Please ask for: Nikita Mossman
Your reference: Non material change
Our reference: DC/22/02173
E-mail: planningyellow@babberghmidsuffolk.gov.uk
Date: 29th April 2022

NON MATERIAL AMENDMENT
TOWN AND COUNTRY PLANNING ACT 1990

Proposal: Application for a Non Material Amendment relating to DC/19/04454 - Removal of double doors to north elevation of workshop.

Location: Grove Farmhouse, Grove Lane, Ashfield Cum Thorpe, Stowmarket Suffolk IP14 6LZ

**Rear Elevation
1:50 @ A3
Amended design**

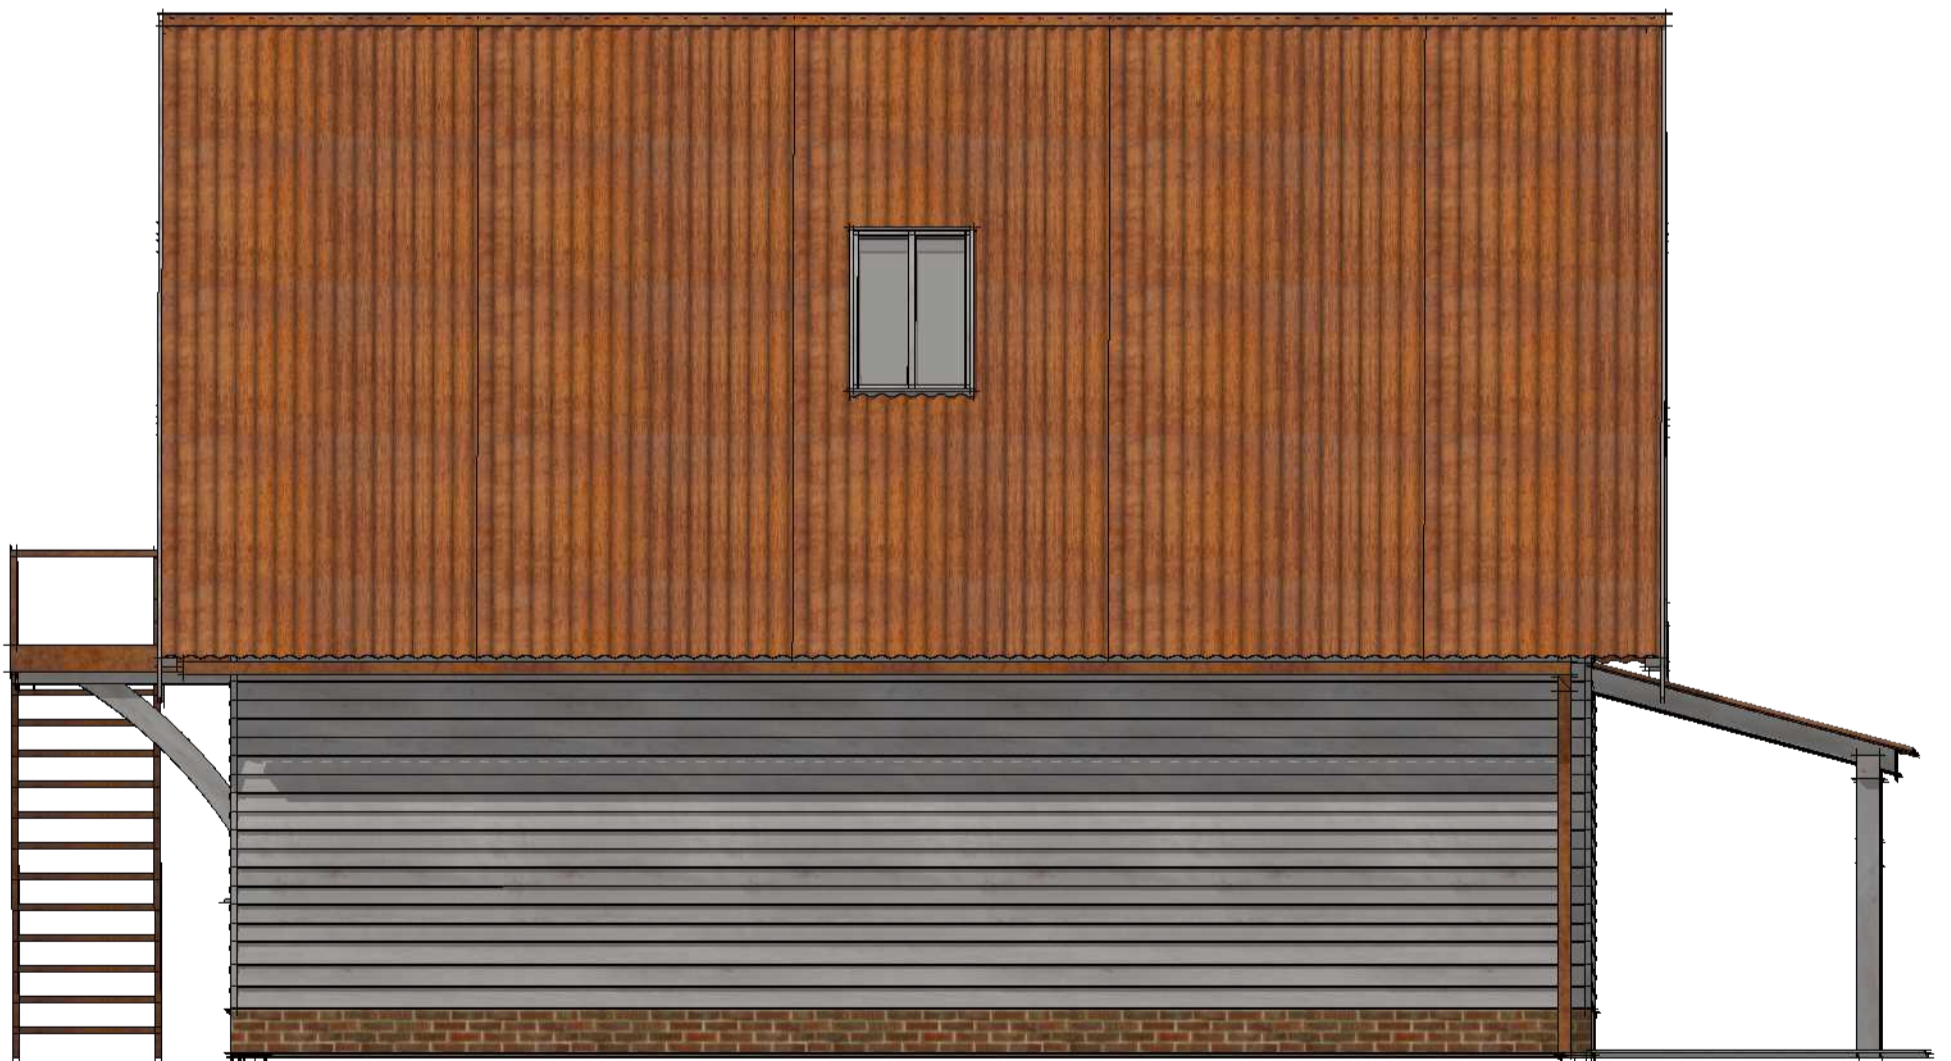
The application proposes the removal of double doors to the north elevation of the workshop, as detailed within the submitted documents received on the 28.04.22. The proposed amendments are not considered to result in significant material planning issues, are considered to be non-material, and as such are considered acceptable.
